Subject: Amendment Report for the HVO North Open Cut Coal Continuation Project SSD-11826681 and HVO South Open Cut Coal Continuation Project (SSD-11826621)

CPHR has reviewed the Hunter Valley Operations Continuation Project Amended Report (dated August 2025), along with all relevant attachments and appendices, with a focus on biodiversity impacts.

Amendment Report for the HVO North Open Cut Coal Continuation Project SSD-11826681 and HVO South Open Cut Coal Continuation Project (SSD-11826621)

Figure 7 – River Red Gum restoration areas

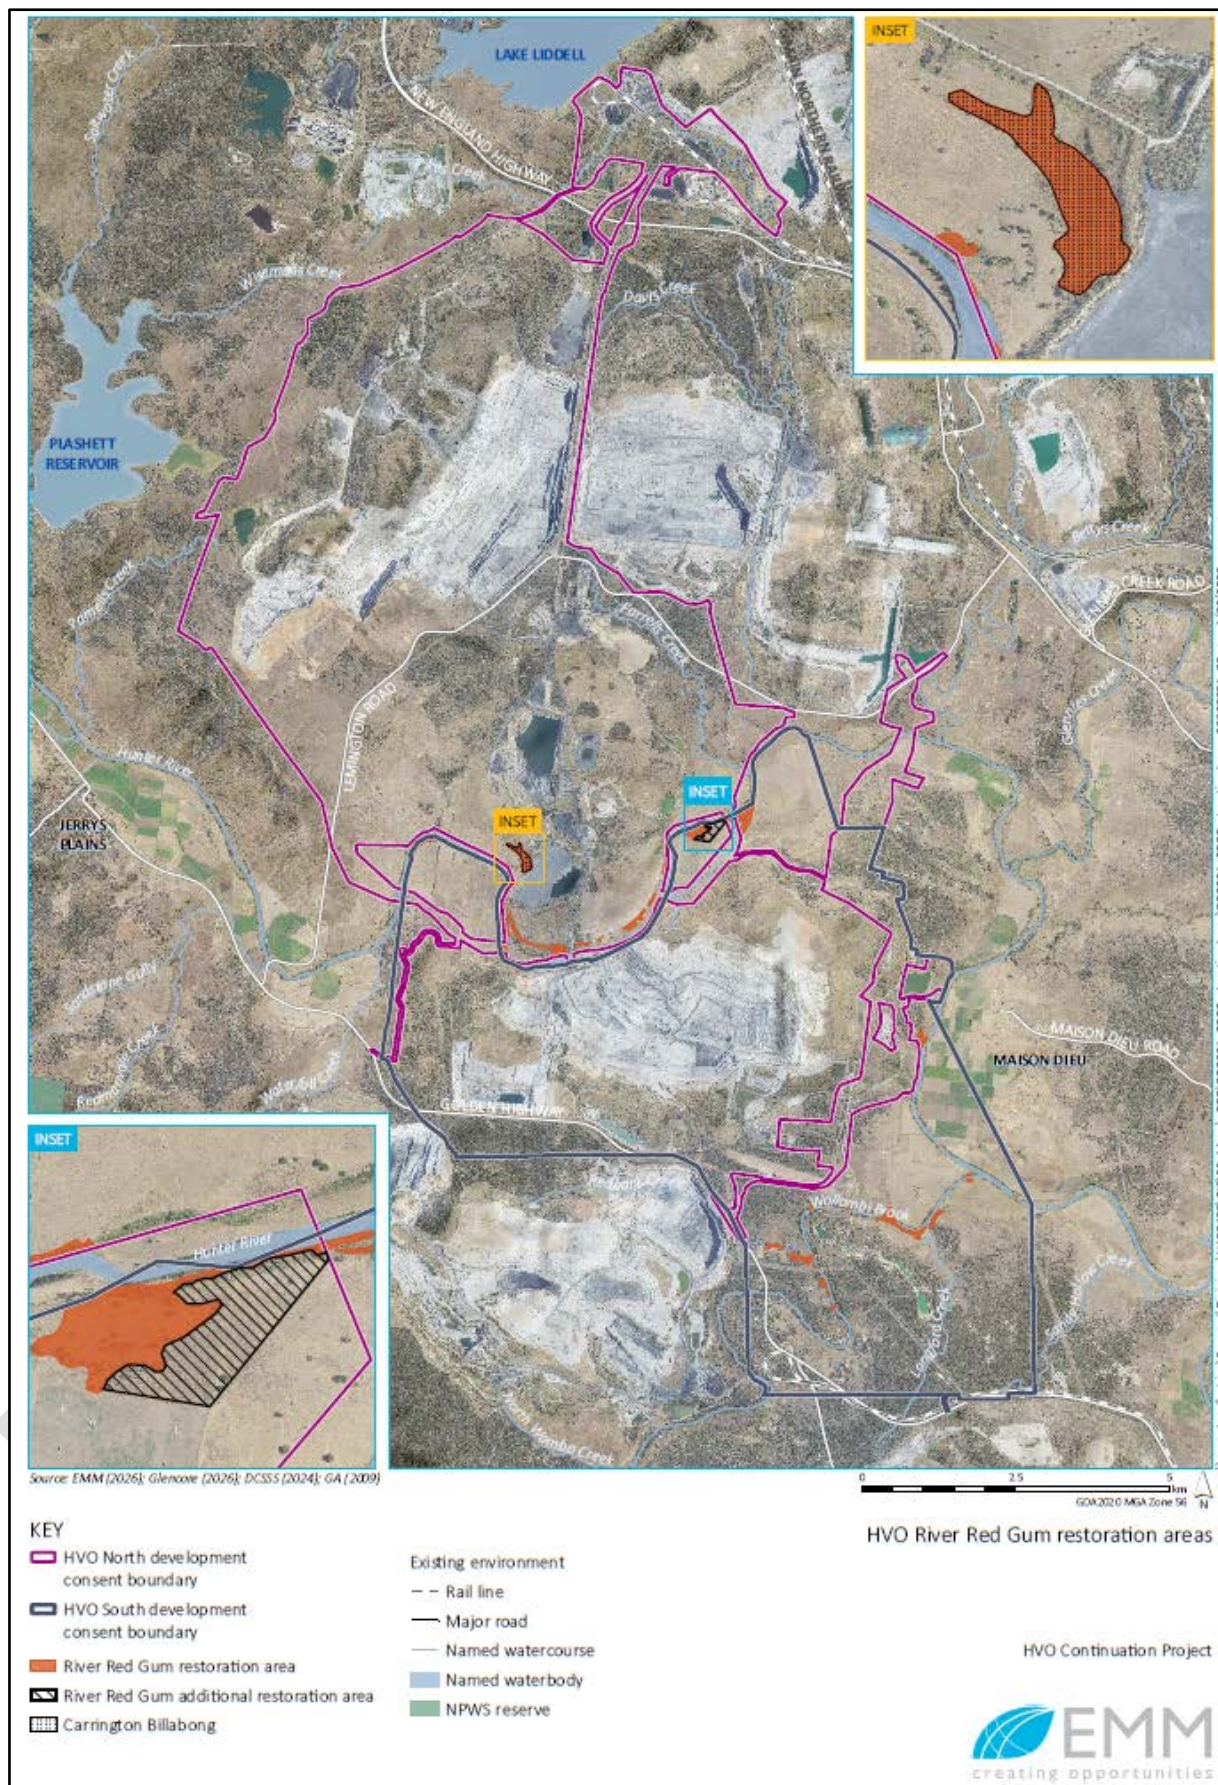
No	Comments	Recommendation
1	<p>The BDAR continues to identify impacts to the Hunter Floodplain Red Gum Woodland EEC, which the Department considers may pose a risk of Serious and Irreversible Impact (SAII).</p> <p>Condition 31 of the consent explicitly states that “the applicant must protect all stands of the Hunter Lowland Red Gum Forest (also identified as Hunter Floodplain Red Gum Woodland Complex in the EA) endangered ecological community within the site, and adjacent lands under the control of the Applicant”. The proposed impacts are in direct contradiction to this consent condition.</p> <p>Furthermore, while the proposed restoration area is larger in size (6.6 ha), it does not represent a like-for-like offset for the impacted area. The restoration site comprises grasslands and exotic pasture with low to moderate native ground cover and contains only one <i>Eucalyptus camaldulensis</i>. This is not comparable to the ecological value of the impact zone.</p> <p>It is also notable that the proposed restoration area borders habitat that appears to be significantly more suitable, including six <i>Eucalyptus camaldulensis</i> specimens, raising questions about site selection.</p> <p>Additionally, the indirect impacts to Warkworth Sands Woodland CEEC have not been adequately addressed.</p>	<p>It is recommended that the proposal be revised to avoid any further impact on the Hunter Floodplain Red Gum Woodland Endangered Ecological Community (EEC).</p> <p>If avoidance is not feasible, the proponent should engage with the Department to identify and secure an area of equal or greater ecological value for protection and rehabilitation. This offset area must not be subject to any existing or proposed rehabilitation or conservation agreements.</p> <p>Ensure that any potential indirect impacts to the Warkworth Sands Woodland CEEC have been assessed and subsequently avoided and/or mitigated.</p>
